From: ECY RE CRO SEPA COORDINATOR <crosepa@ecy.wa.gov>
Sent: Tuesday, November 10, 2015 4:01 PM
To: Lindsey Ozbolt
Subject: Comments for Big Creek Trails
Attachments: 4829 DK Professional Consultants Inc.pdf

Re: RZ-15-00001, SD-15-00002, & SP-15-00003

Thank you for the opportunity to comment during the optional determination of nonsignificance process for the Big Creek Trails Planned Unit Development on 285 acres that will include 58 residences, proposed by D.K. Professional Consultants, Inc. We have reviewed the documents and have the following comments.

RZ-15-00001

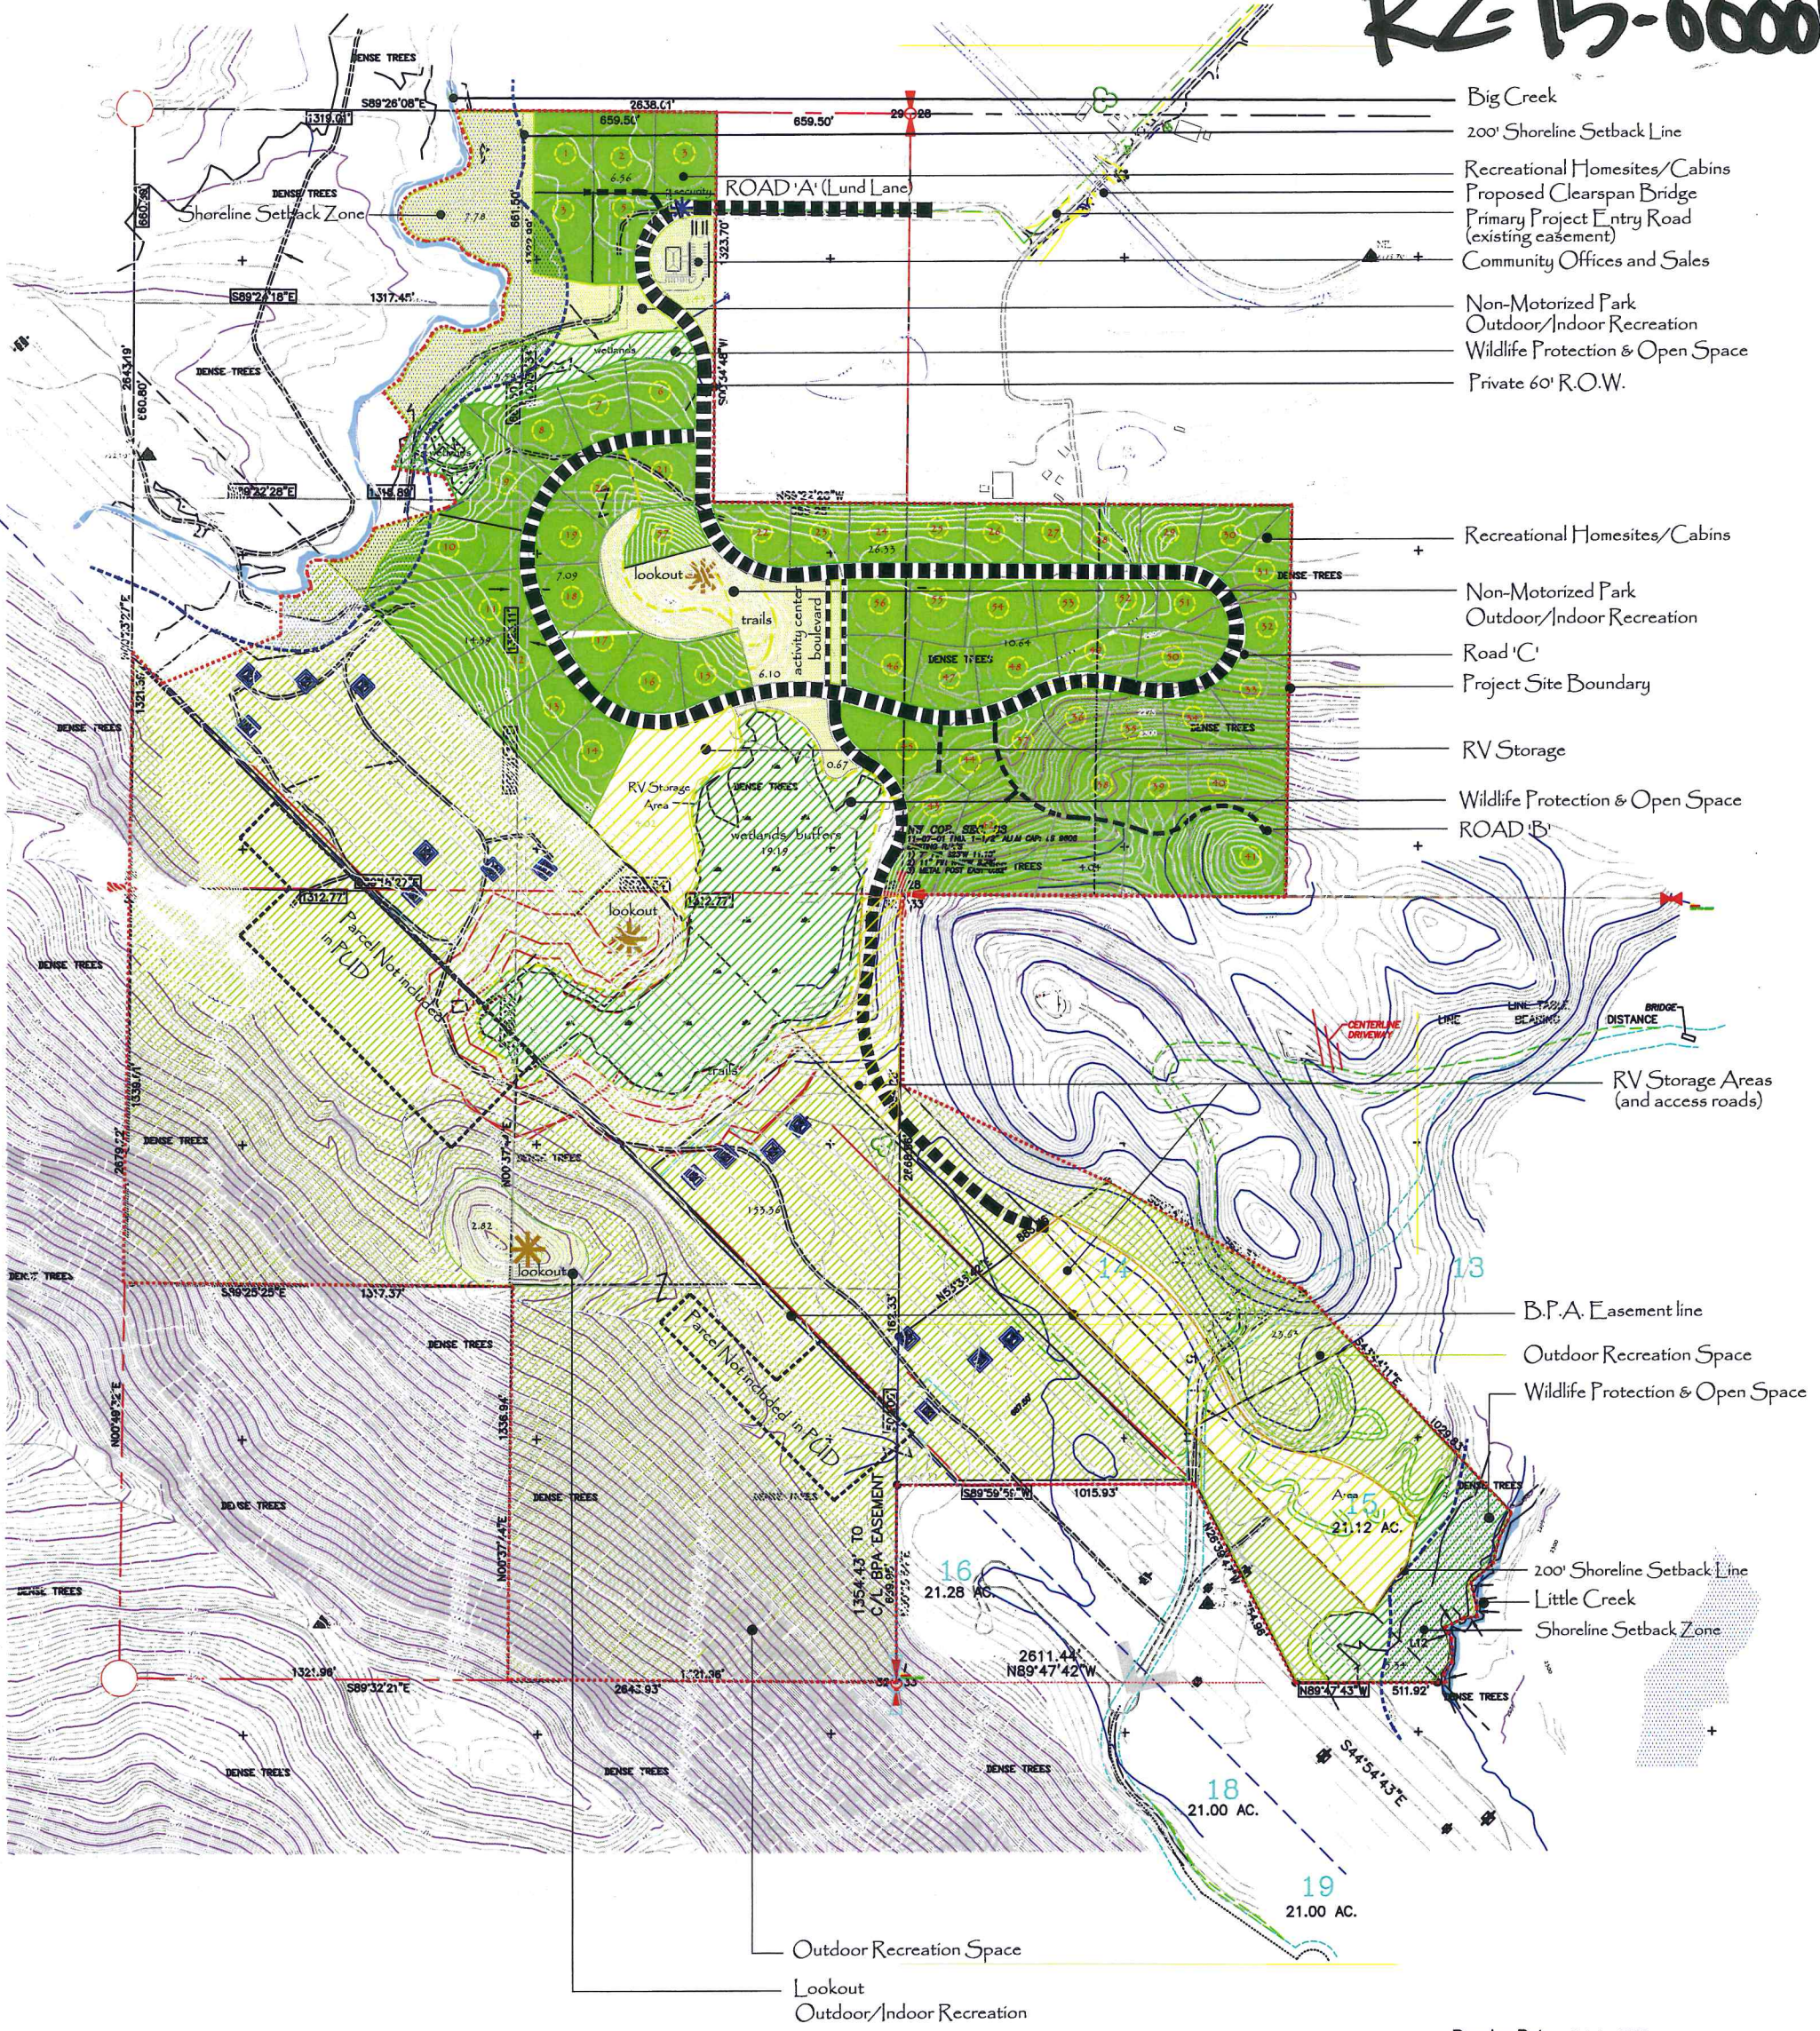
A site map which clearly shows the proposed parcel or development areas as opposed to open space areas and wetland areas should be provided. All existing and proposed roads should be shown on the same site map. The submitted maps are difficult to read (possibly due to scanning deficiencies) and to project onto the landscape. We recommend the use of aerial photos or contour maps as the base map where the items would be placed. The maps need to reflect the recent amendment which states that there will be no development within shoreline jurisdiction.

discusses weather and climatic cycle conditions relevant to observations of hydrologic regime in the field and at field data points. It would be most helpful if a contour map with 2-foot contour intervals could be used as a base map which shows the locations of both wetland areas and proposed lot boundaries, roadways and any existing or proposed infrastructure.

The wetland boundaries shown in the updated report should be verified by agencies with jurisdiction before final lot configuration approval. Wetland areas and their buffers should be located in open space that is not part of lot areas that can be developed.
